2023/0783

Erection of single storey rear extension to rear of the single storey cottage, excavation works to rear to create new levelled out rear garden with paving surface and replacement retaining walls and fences around the perimeter.

Chimney Cottage, The Avenue, Wortley, Sheffield, S35 7DB

Proposed Site

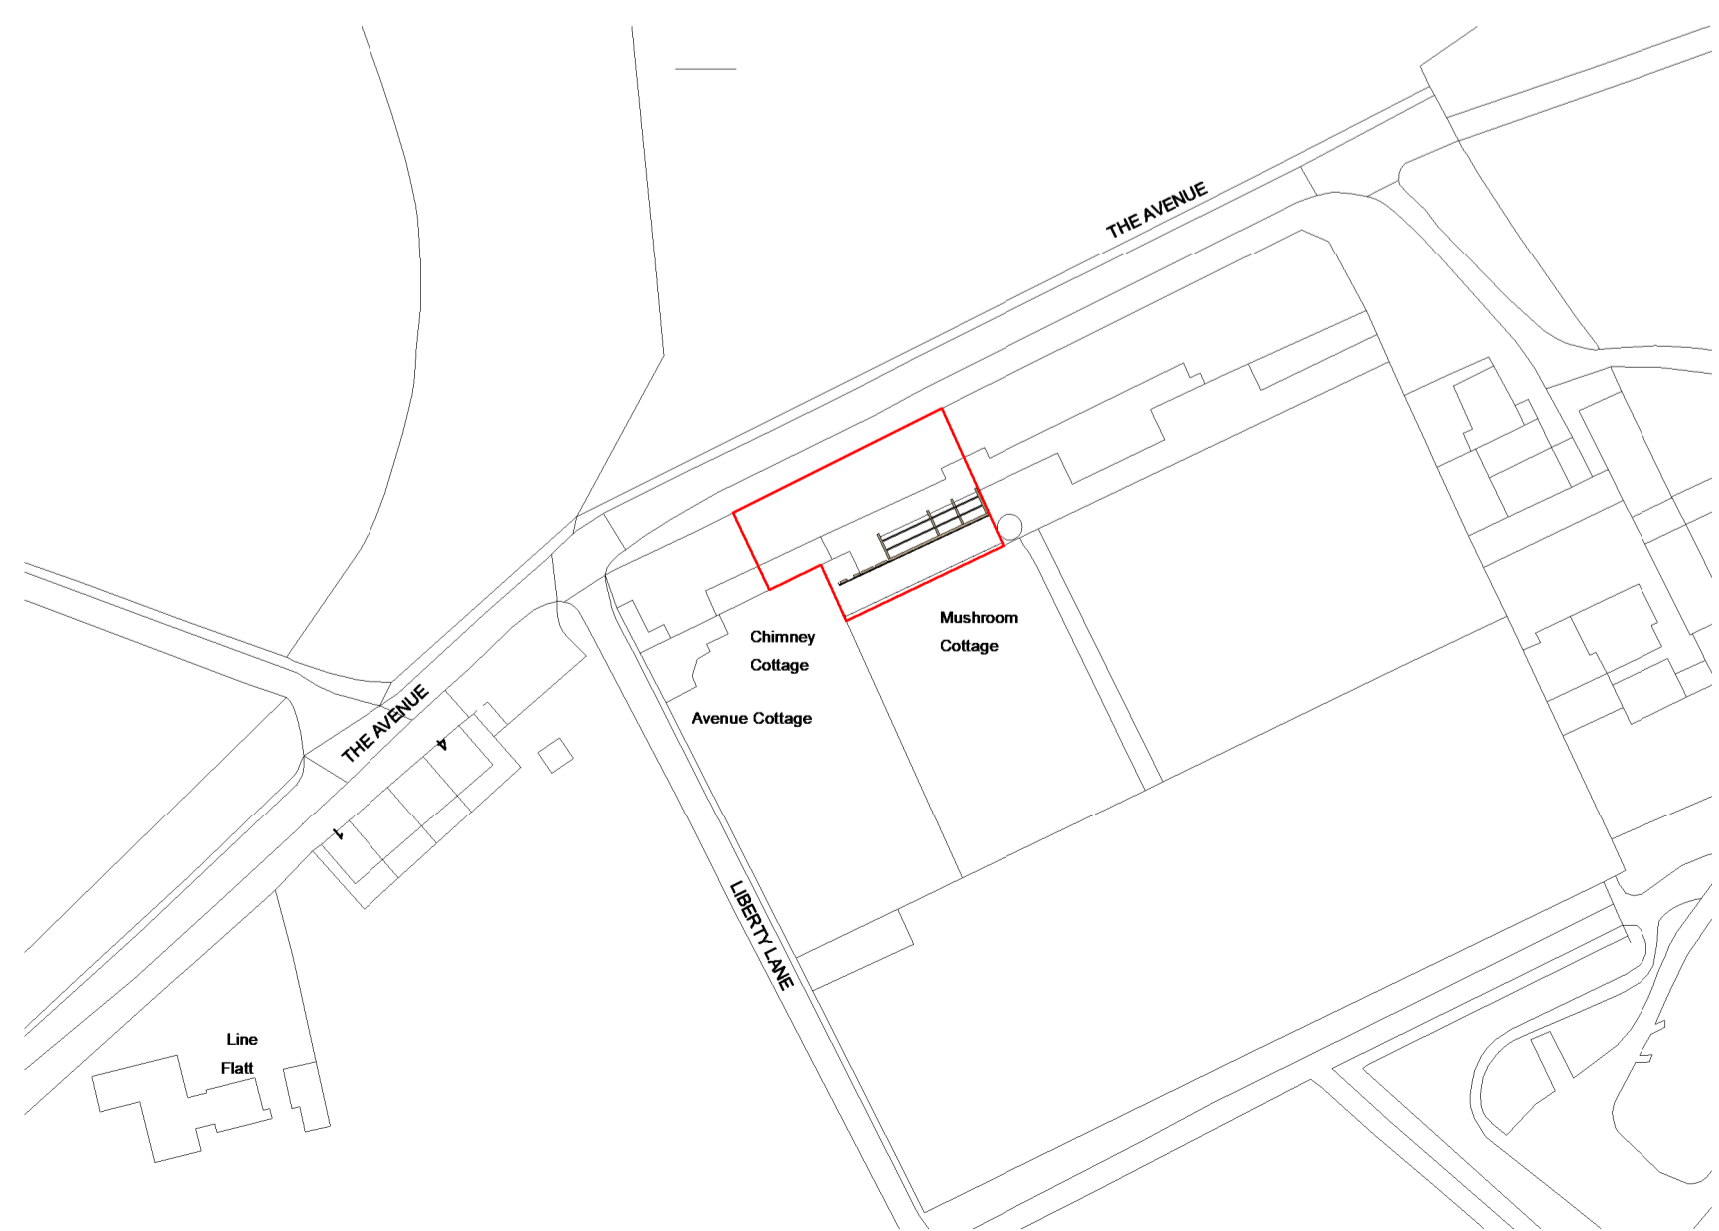
While historic mapping suggests that glass house structures were located along the inner wall, the documentation provides no assessment of the impact on the significance of the kitchen garden and the sense of enclosure created by the garden walls. The creation of retaining walls and boundary fence potentially harm the character and appearance of the kitchen garden, as well as undermining the historic form and use of the gardens and understanding how they relate to the listed buildings and parkland. HB&P suggest that a detailed heritage impact assessment is required in this instance to meet the requirements of para. 200 of the NPPF.

Upon commencement of development a plan outlining details of boundary treatments to be erected, including positioning, shall be submitted to and approved in writing by the Local Planning Authority. The boundary treatment shall be completed before the dwelling is occupied. Development shall be carried out in accordance with the approved details and shall thereafter be retained.

Title
Proposed Plans & Elevations

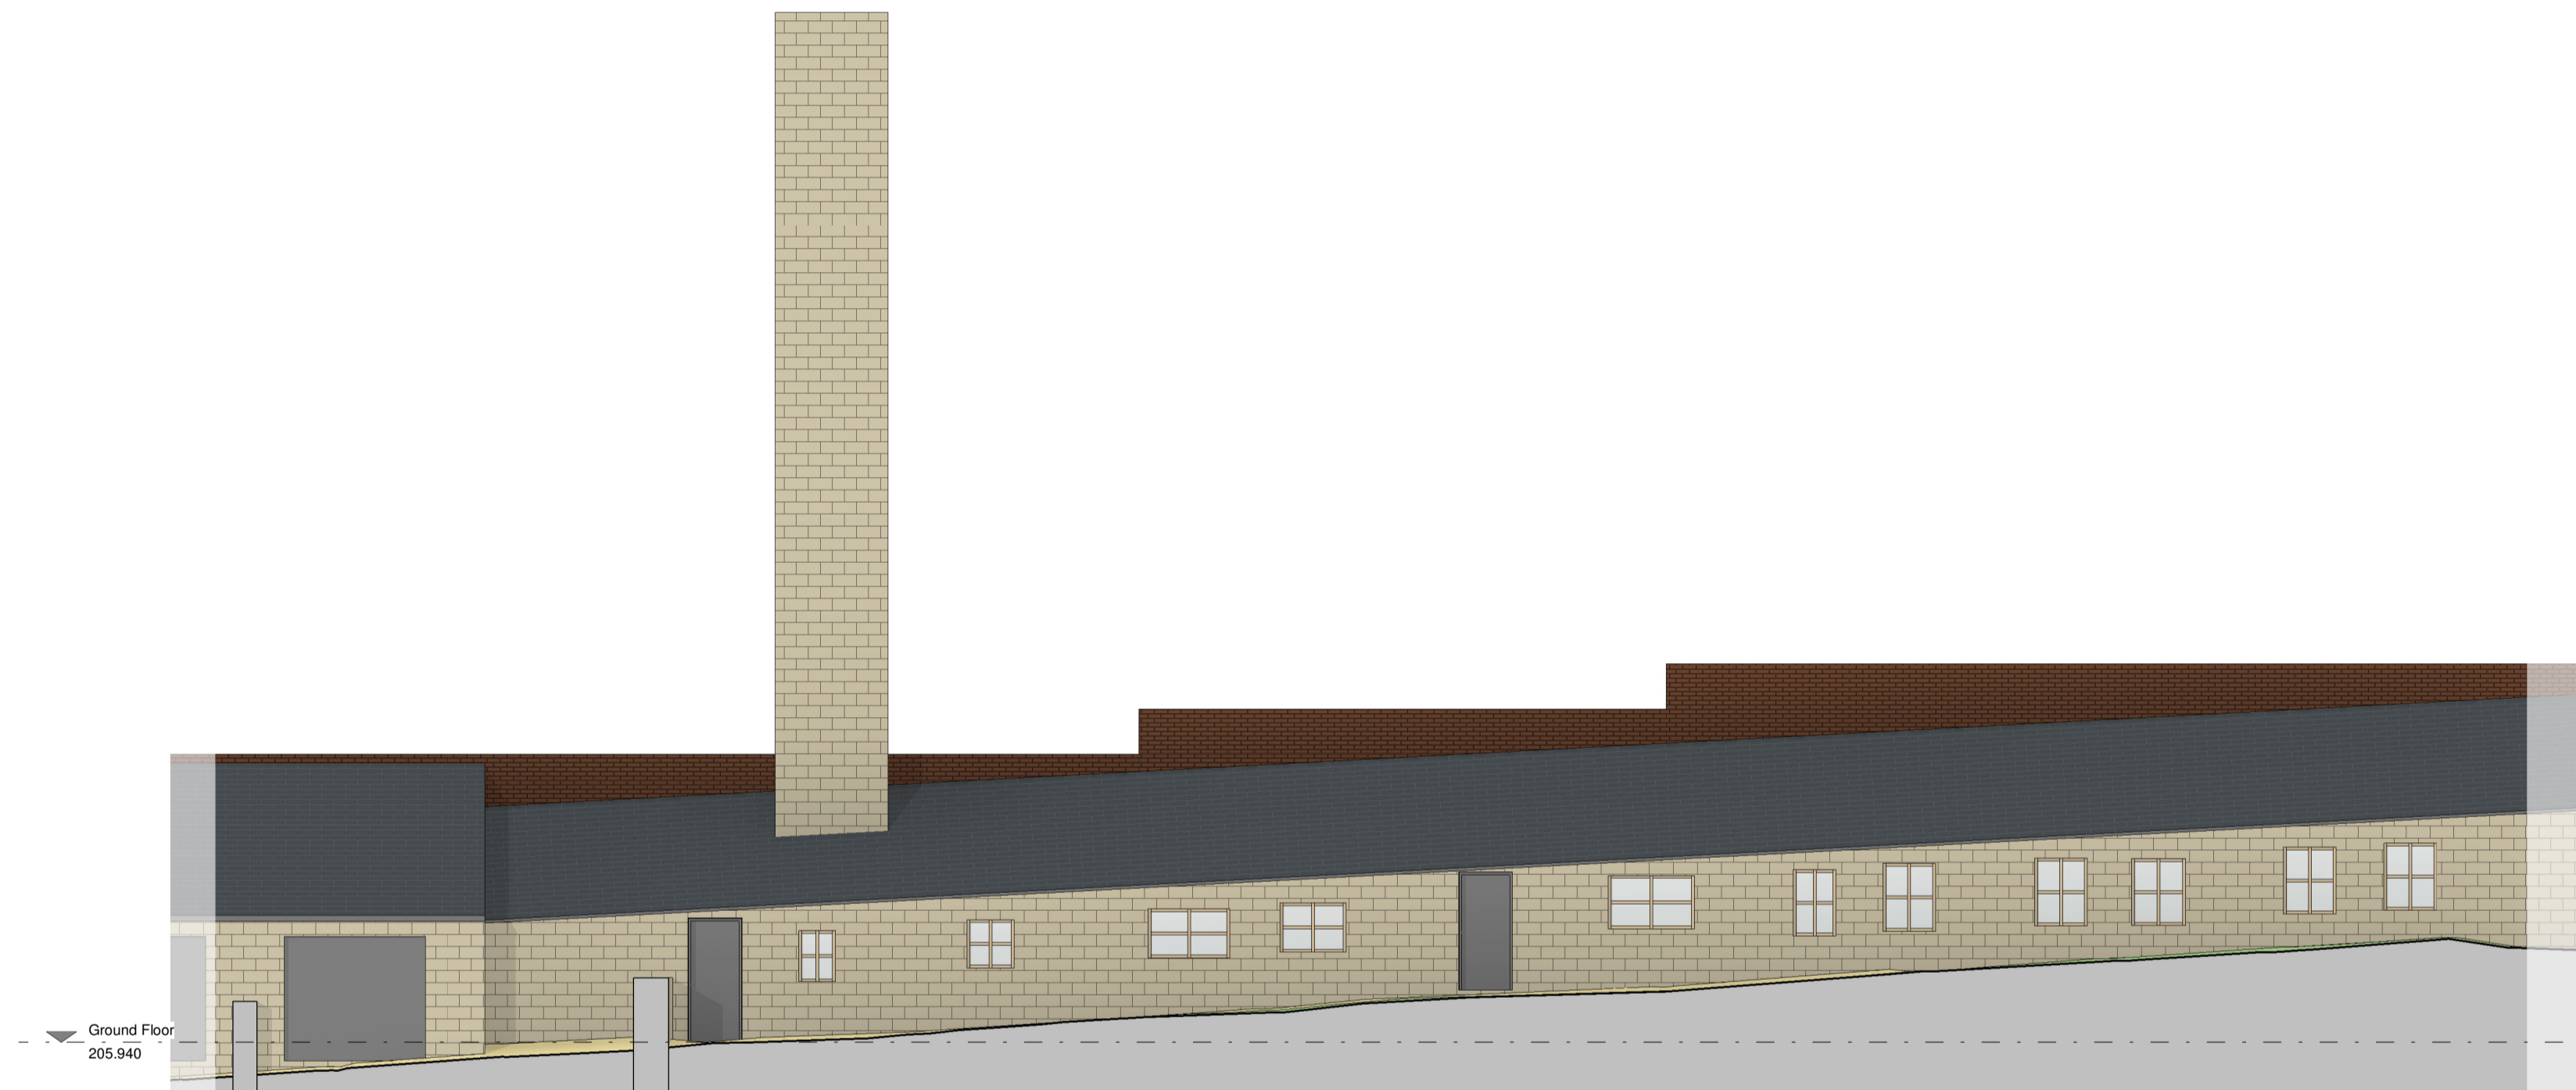
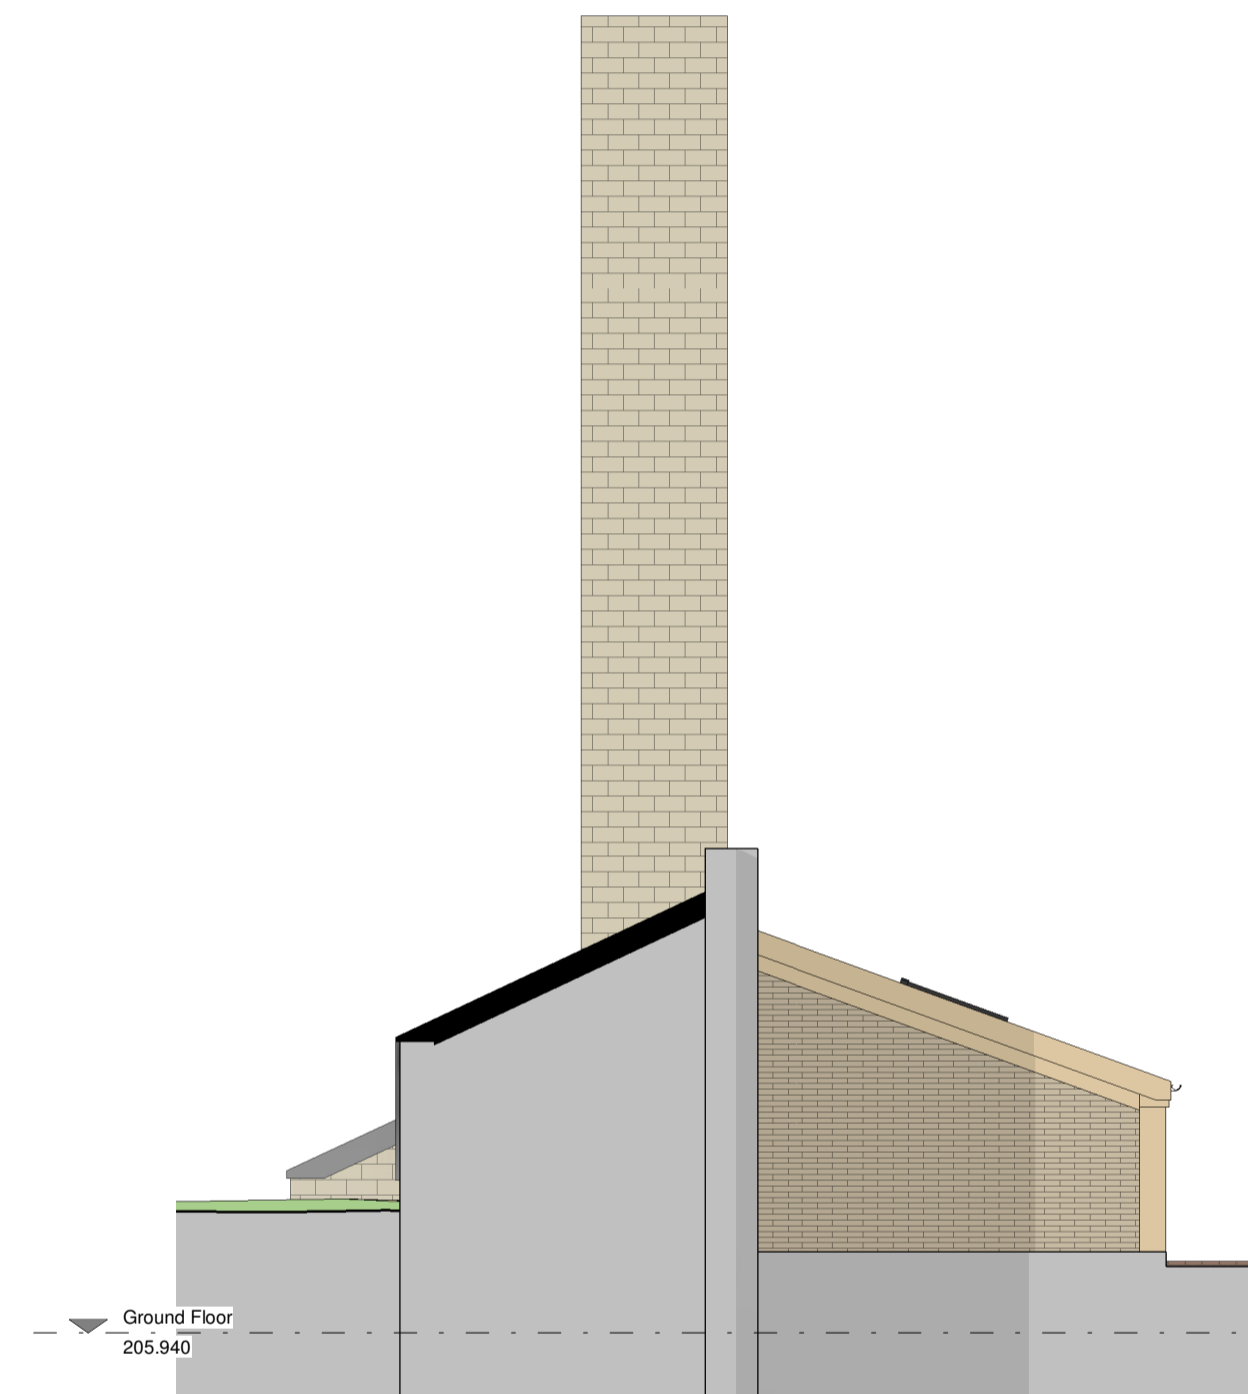
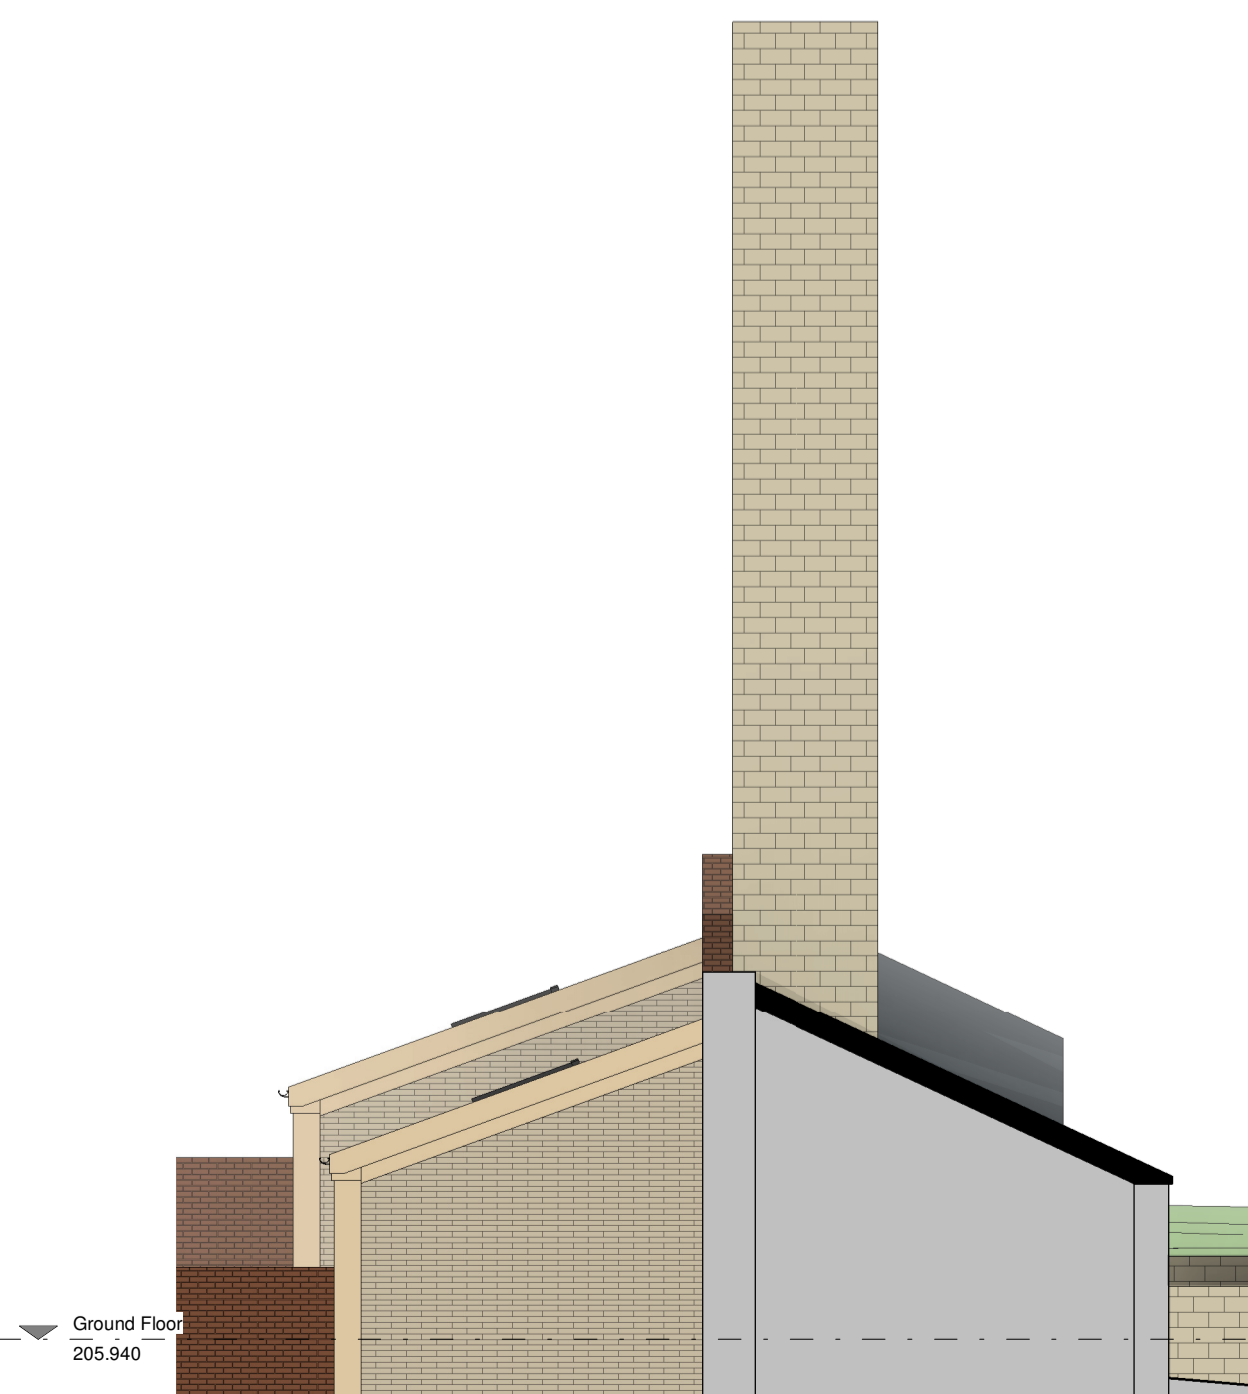
As mentioned previously the proposal has been amended during the application process which has resulted in a reduction in the scale and massing of the proposed extension which now follows the step down of the original building, a reduction in the ridge height, a reduction in the amount of glazing and an increase in the masonry along the southern elevation, along with the removal of roof lights and the alteration to the southern boundary treatment.
